Outer Dowsing Offshore Wind

Schedule of Changes for Plans

Deadline 2

Document Reference: 2.0

Sheet 32

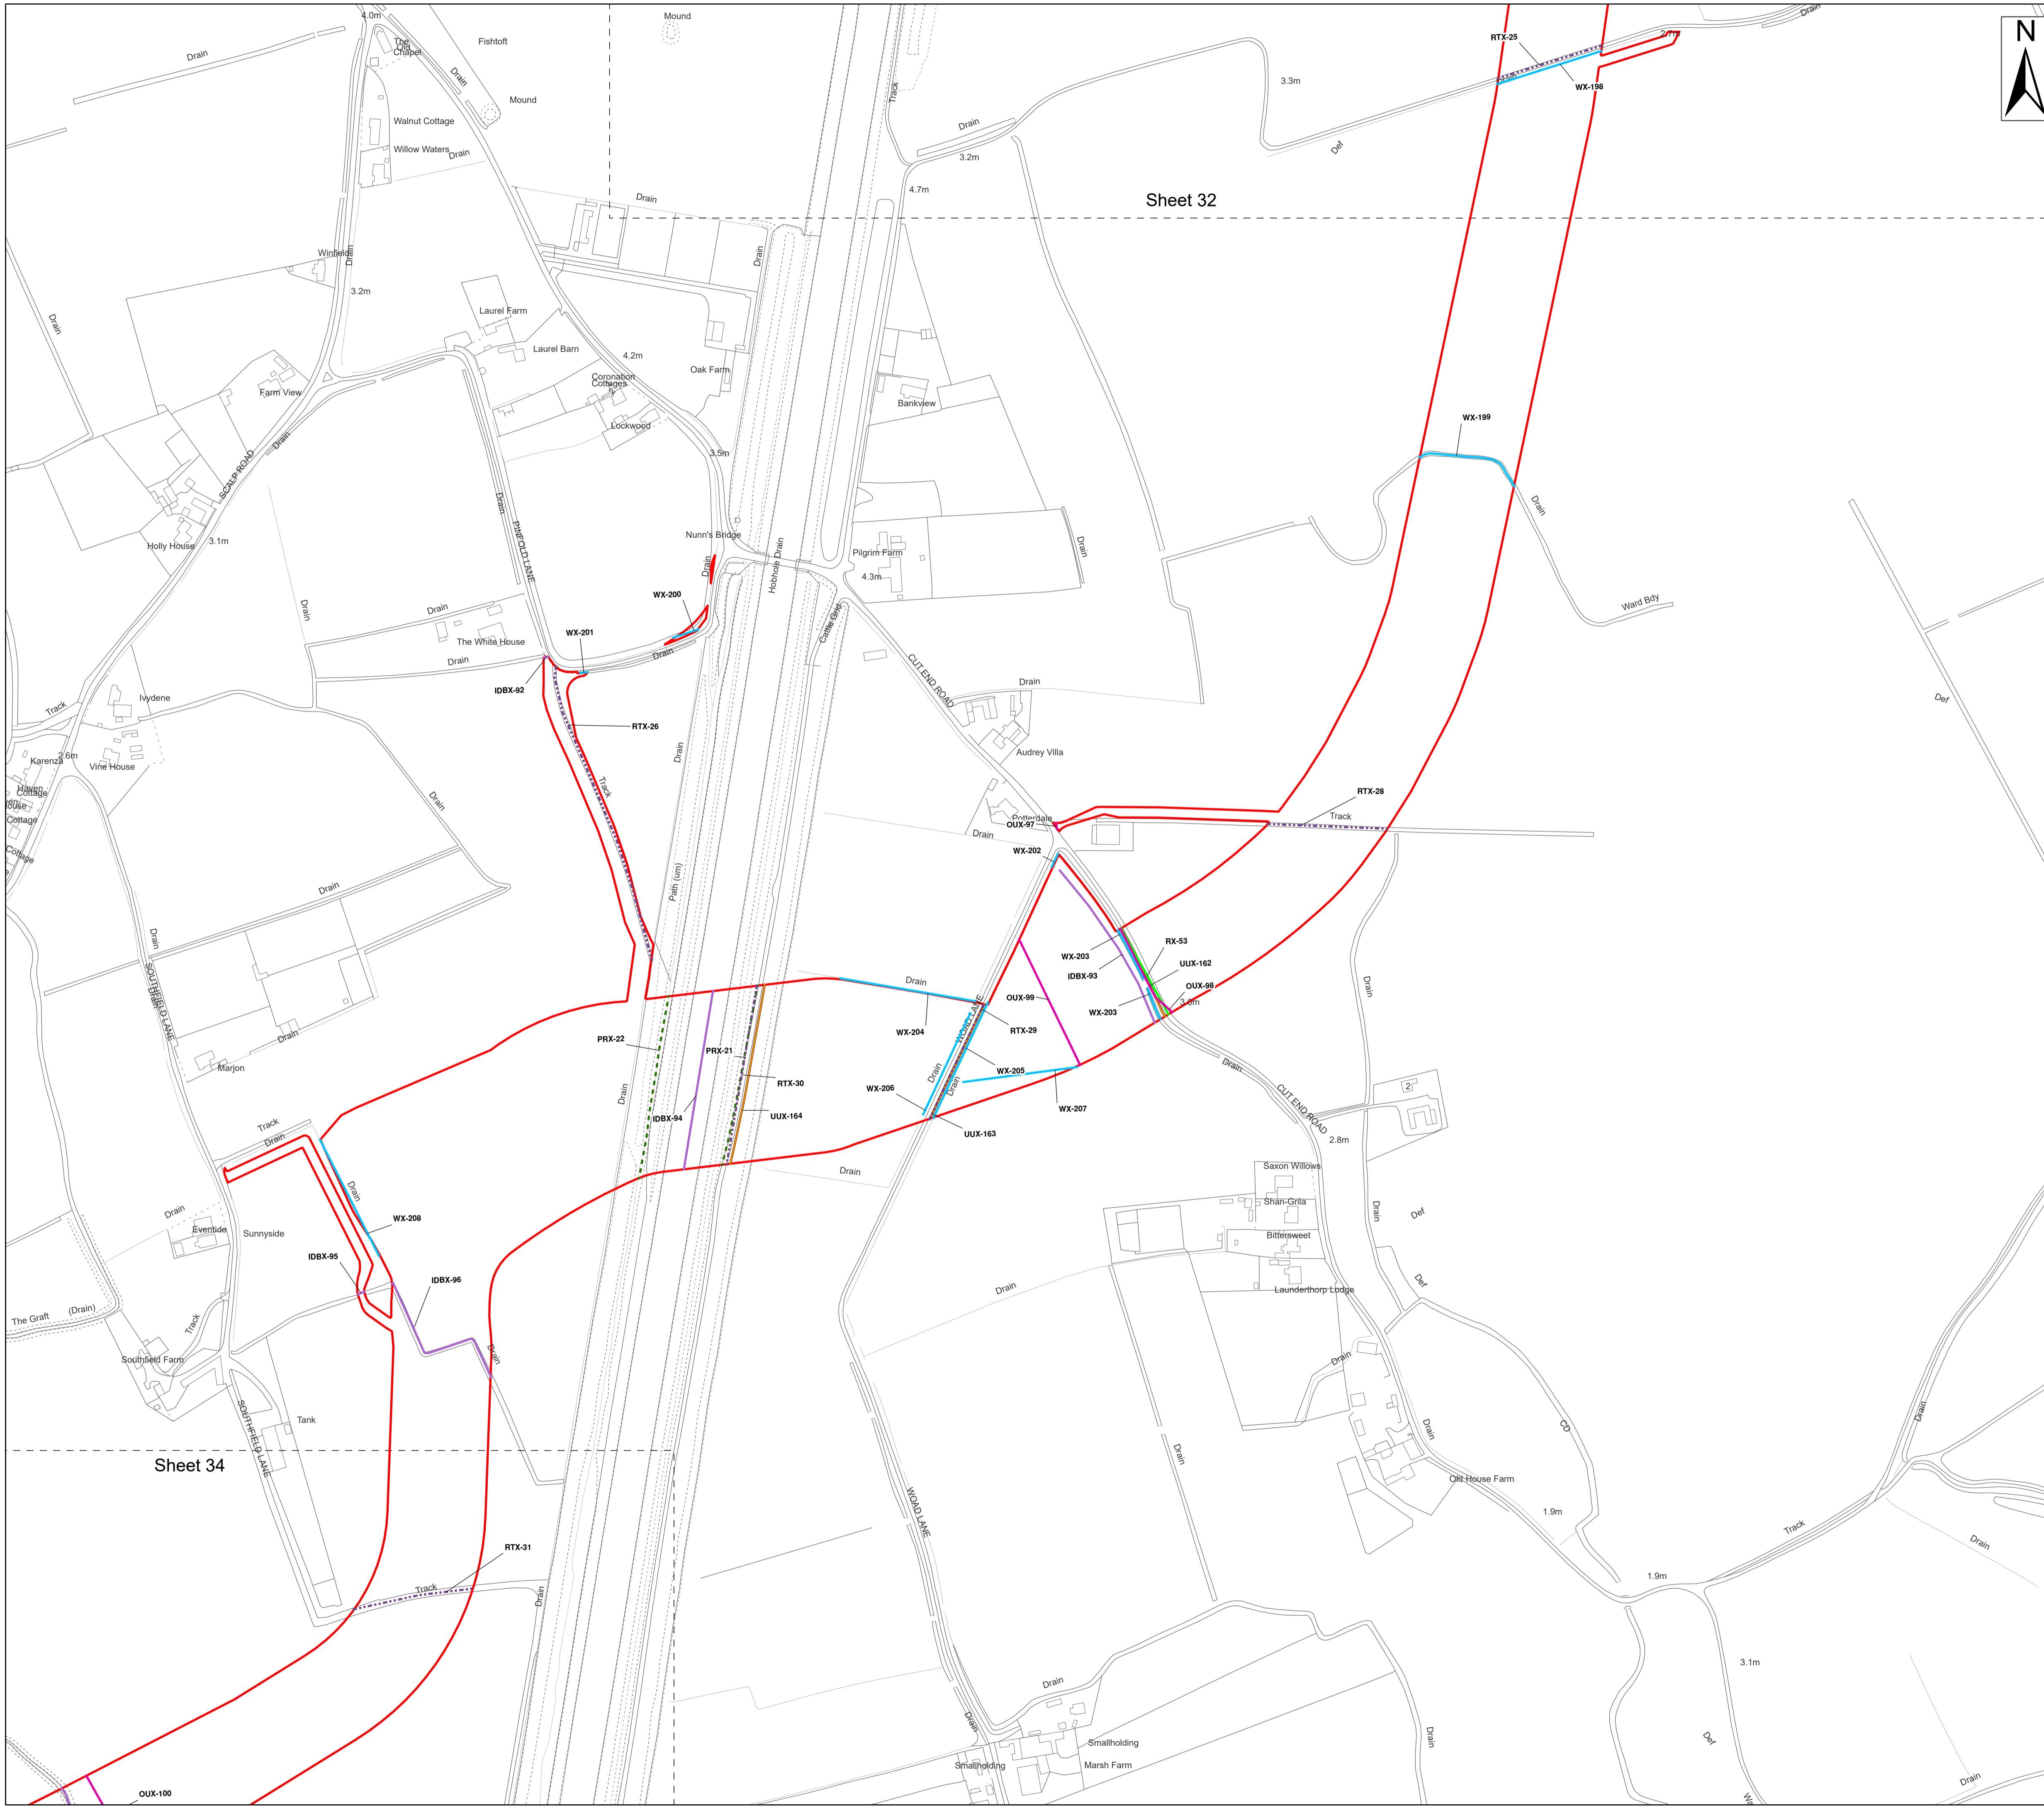
9. The Onshore Crossing Plan (2.18) and Public Rights of Way Plan (2.10) have been updated to show proposed new public rights of way (PRoWs) identified through consultation with Lincolnshire County Council (identified by their Boston Borough Council planning application reference numbers), along with the indicative routes for diversions. These proposed new PRoWs have also been included in the associated Crossing Schedule (6.3.3.2). The proposed new PRoWs and associated diversions (as appropriate) are shown on the following sheets of the Onshore Crossing Plan by reference to the crossing (PRX) or diversion reference (PRDX) and on the Public Rights of Way Plan by reference to the planning application reference number:

Plan sheet number	Crossing Reference (Plan 2.18)	Plan PROW Plan Reference (Plan 2.10)
31	PRX-20a	OMC B/24/0191 between points OMC36 and OMC 37
32	PRDX-4	Diversion between points CTD9 and CTD10
32	PRX-20b	CTD B/24/0197 between points CTD9 and CTD10
32	PRDX-5	Diversion between points CTD11 to CTD12
32	PRX-20c	CTD B/24/0197 between points CTD11 and CTD12 and OMC B/24/0197 between points OMC38 and OMC39
33	PRX-20d	OMC B/24/0198 between points OMC40 and OMC41
33	PRX-20e	CTD B/24/0198 between points CTD13 and CTD14 and OMC B/24/0198 between points OMC42 and OMC43
33	PRDX-6	Diversion between points CTD13 and CTD14

2.18 Onshore Crossing Plan					
2.18	N/A	November 2024	V4	Updated to remove proposed public rights of way following consultation with LCC.	Removal of previously shown proposed PROWs and associated diversions.

Plan Reference Numbers	Plot Number(s) if appropriate	Date of Change	Revision Change	Change Made	Reasons for Change
					Removed from: Sheet 31: PRX-20a, Sheet 32: PRDX-4, PRX-20b, PRDX-5, PRX-20c, Sheet 33: PRX-20d, PRX-20e and PRDX-6.
Deadline 1
